To: Jeff Watson, CDS
From: Holly Myers, Environmental Health Supervisor
Date: April 15, 2015
RE: BL-15-00003

After review of this BLA, it appears that the proposed changes will incorporate the existing home, water source access and septic system on lot #13.

Pine Lock Sun III

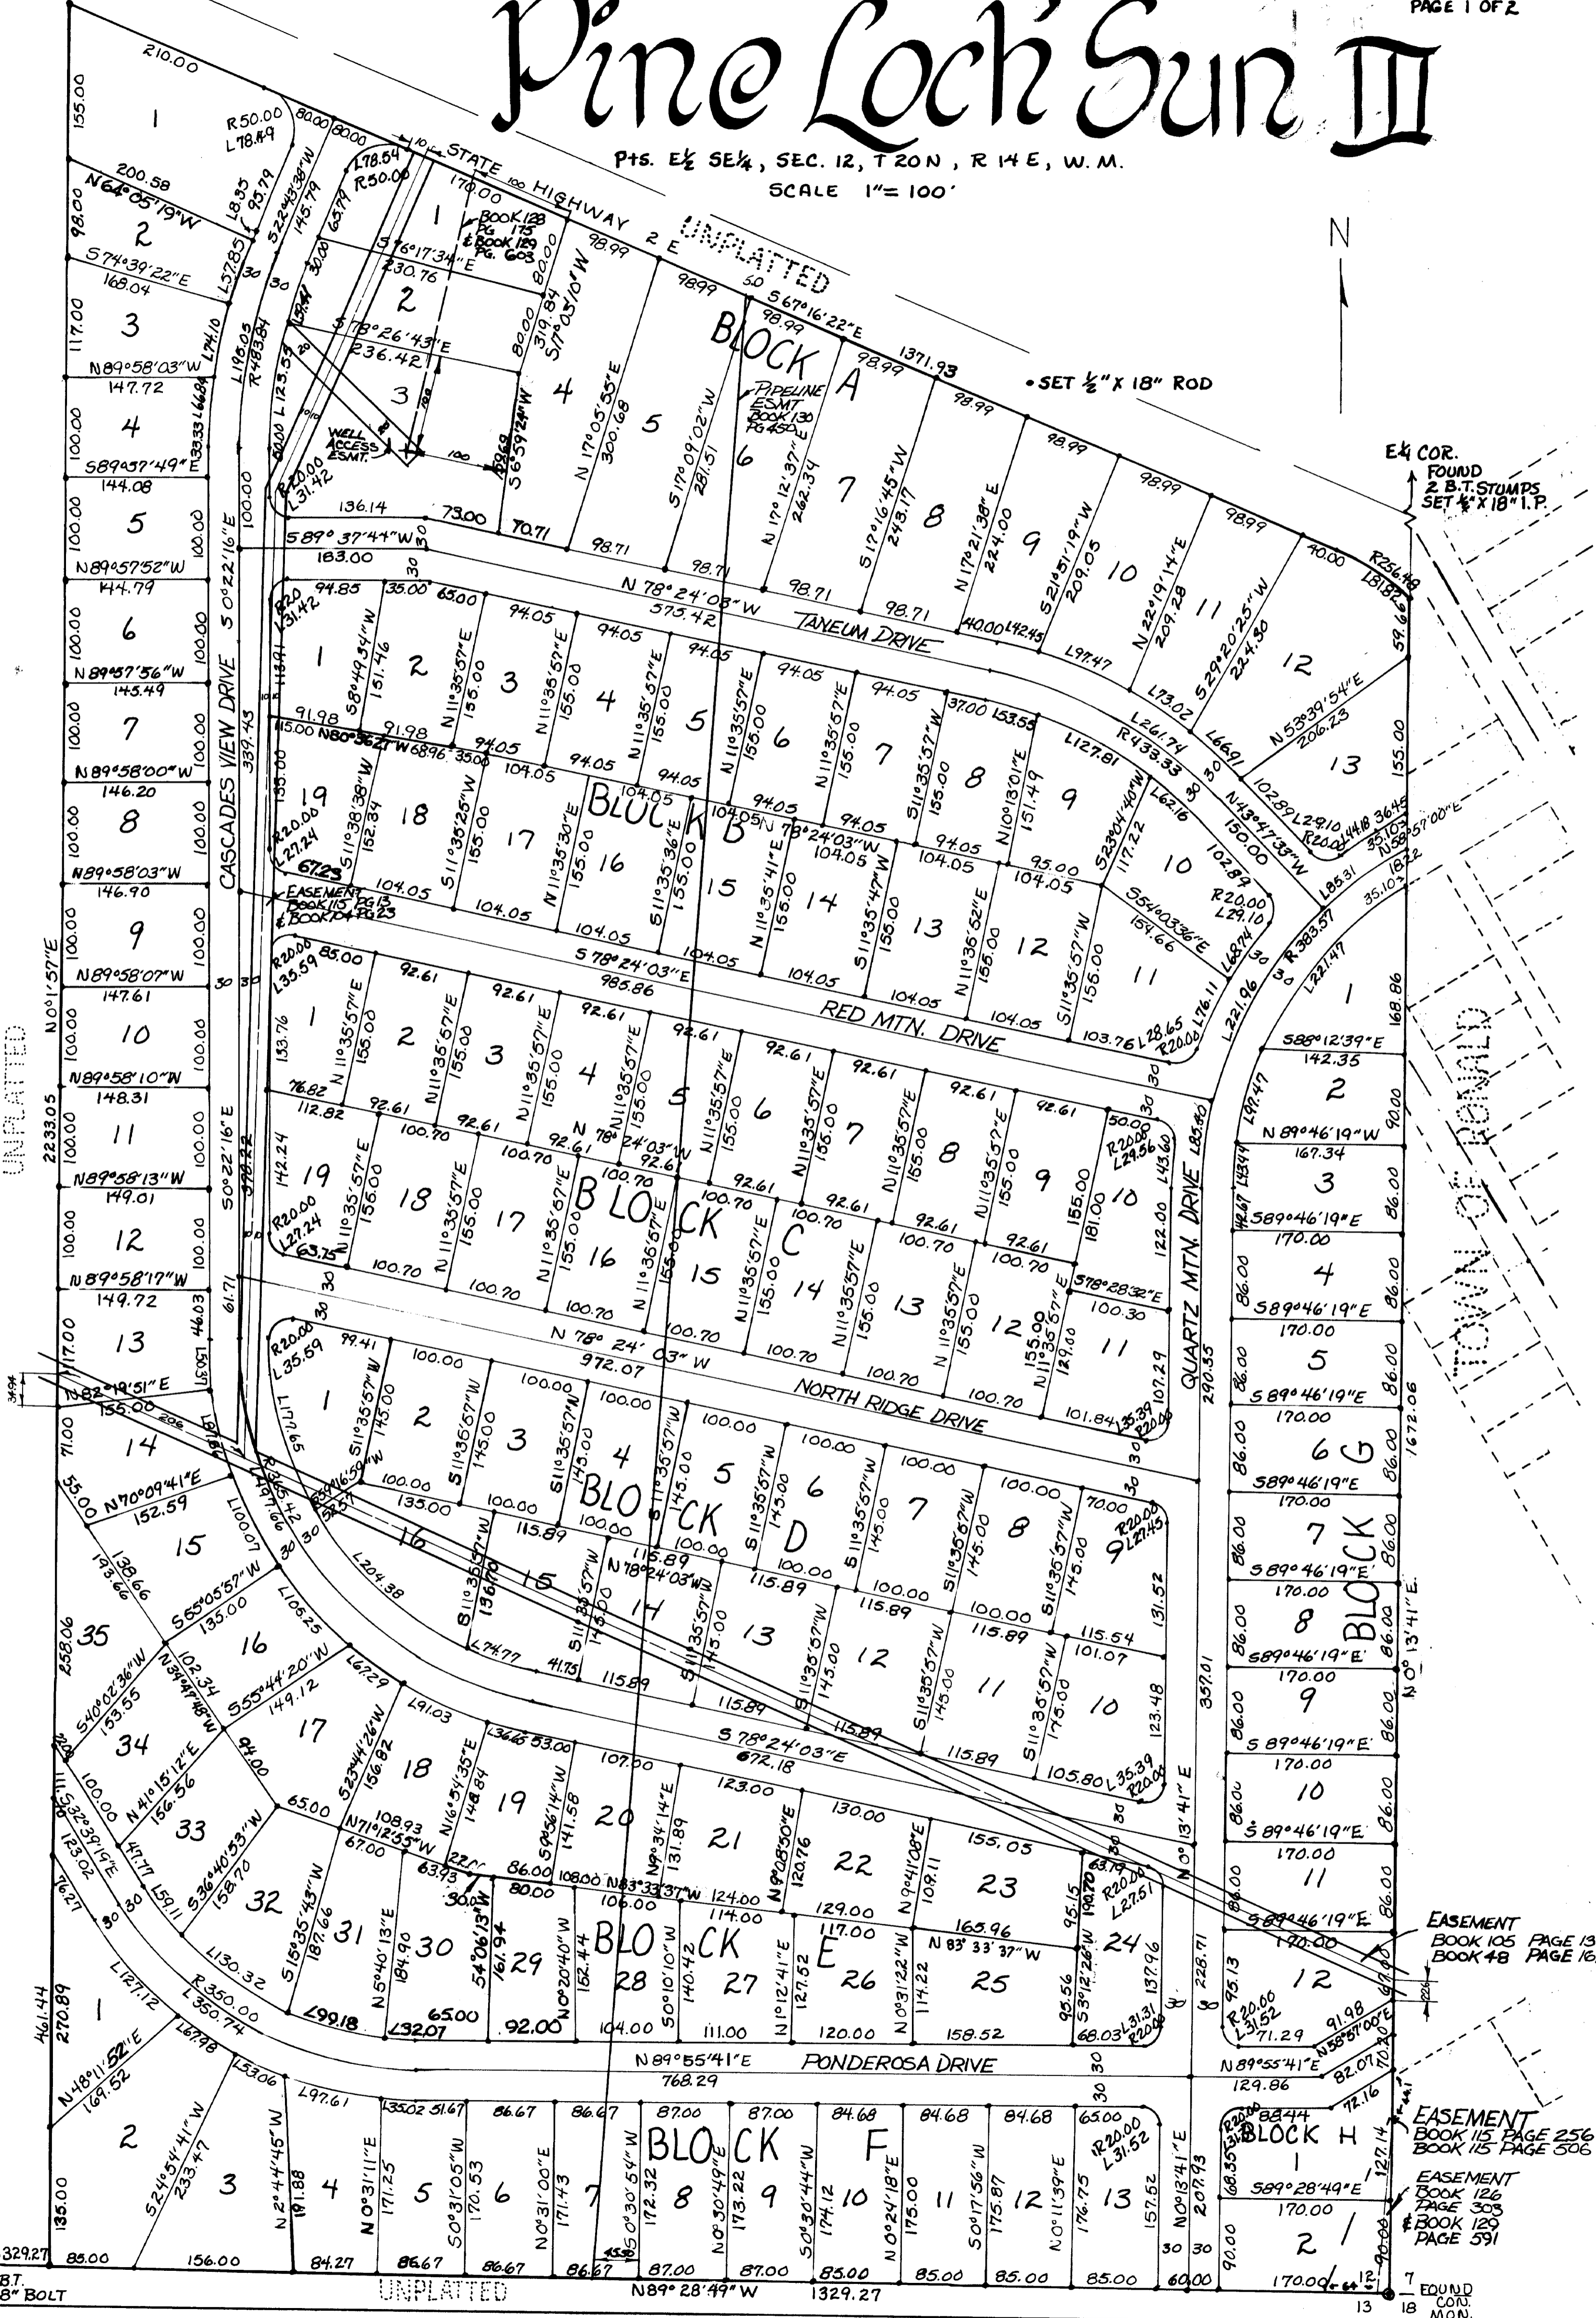
Applicant must provide accurate records proving the proposed boundary line does not lie within 5 feet of the existing septic drain field east of the proposed boundary line. There is no existing septic system design or as-built matching the site plan included in this application packet; therefore location of the existing drain field with respect to the boundary line is unknown. Until this information is provided, Kittitas County Public Health Department does not recommend approval of this application.
